Our ref: HA/2016/118493/01-L01
Your ref: LU/201/16/RES
Date: 22 August 2016

**APPROVAL OF RESERVED MATTERS FOLLOWING OUTLINE CONSENT
LU/229/10/ FOR APPEARANCE, LANDSCAPING, LAYOUT & SCALE FOR 85 NO.
DWELLINGS WINDROOS NURSERY WORTHING ROAD LITTLEHAMPTON BN17
6LY**

Environment Agency Position

TRENCH SOAKAWAY - TYPICAL DETAIL
N.T.S

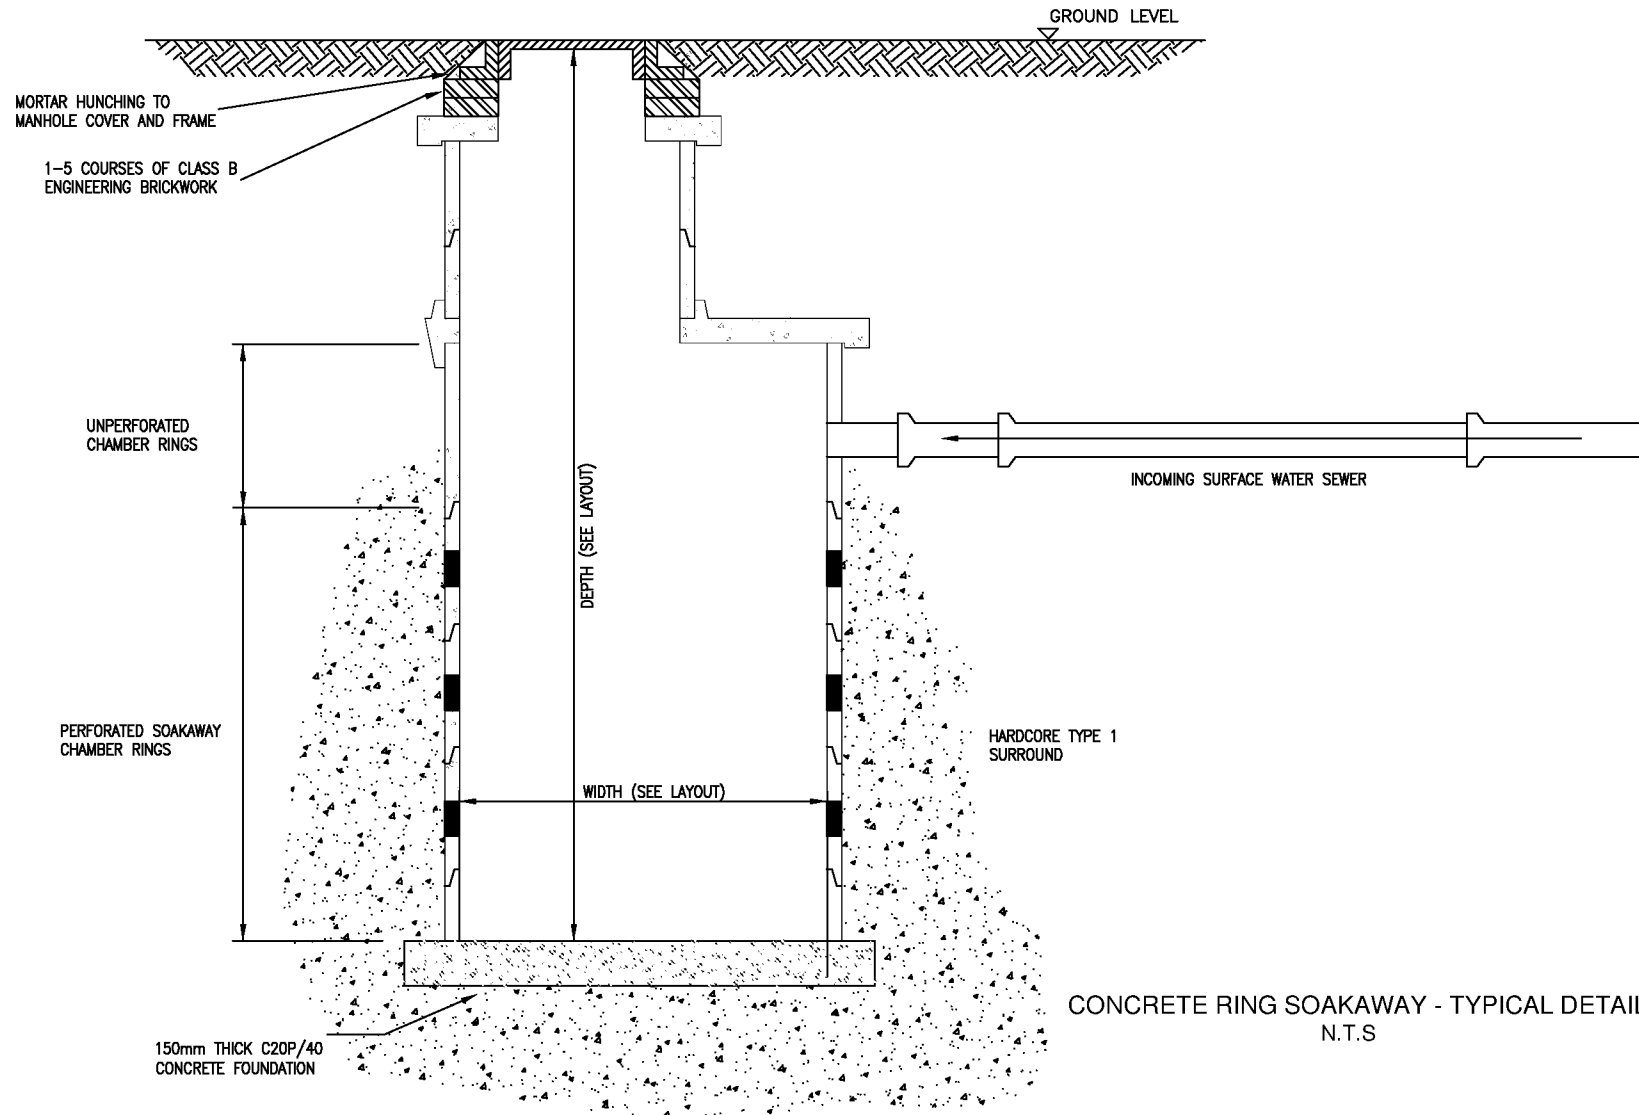
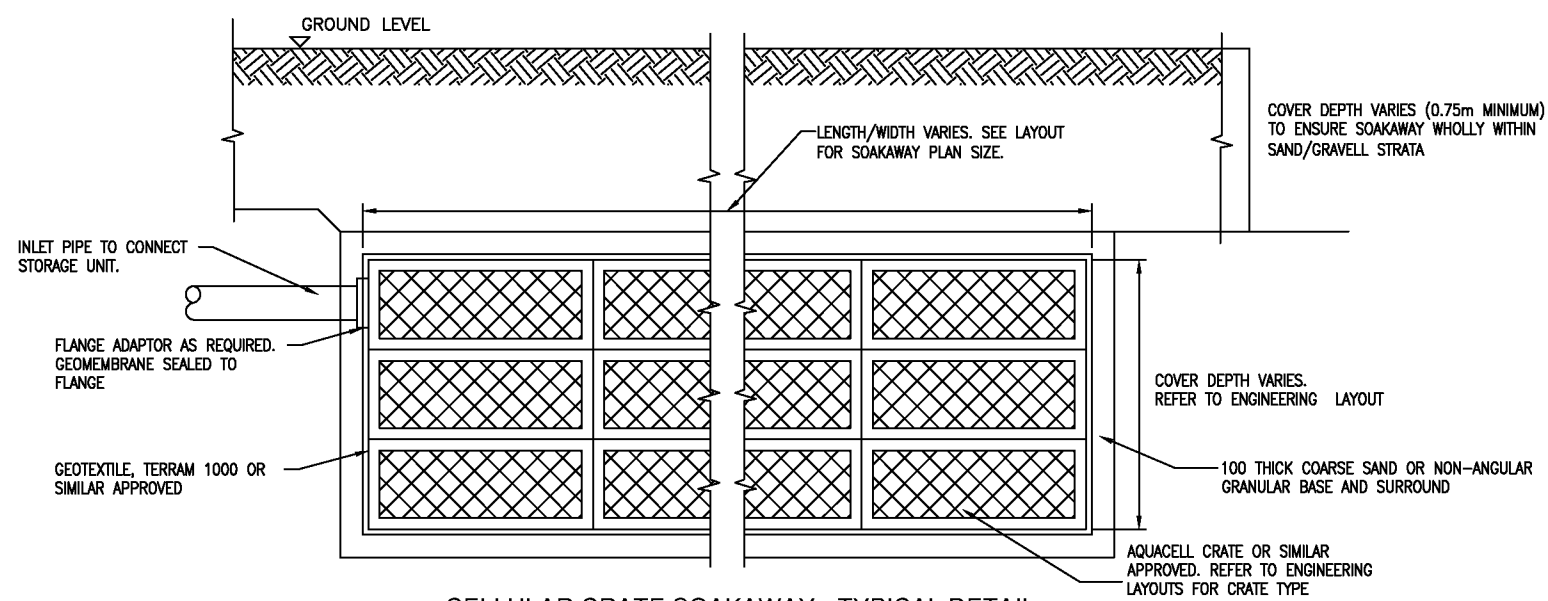
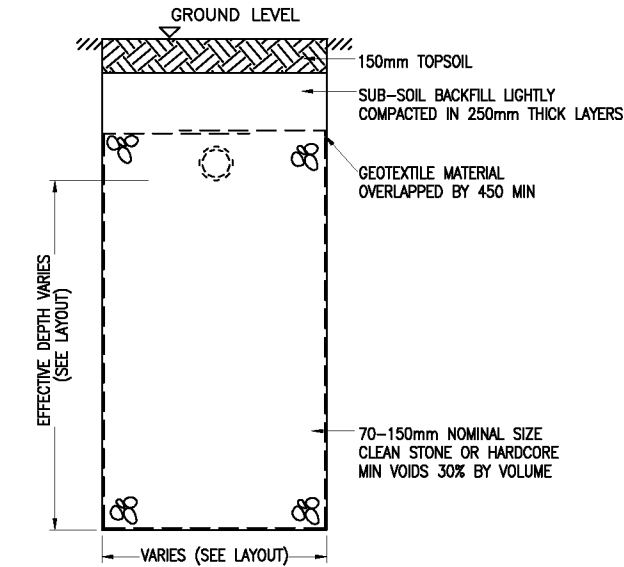
We have reviewed the Engineers report on Drainage and the infiltration structure plan. The proposal is to discharge surface water in to 2 different sections of the site, the Northern and Southern Section. The disposal will be via concrete ring soakaway and a crate soakaway design.

Whilst calculations have been provided, no detailed pollution prevention measures have been proposed within the report and plans. Pollution prevention devices or scheme needs to be developed based on the type and quantity of potential pollution runoff from this type of development. Further details will need to be provided in due course in order to discharge any of the previous conditions.
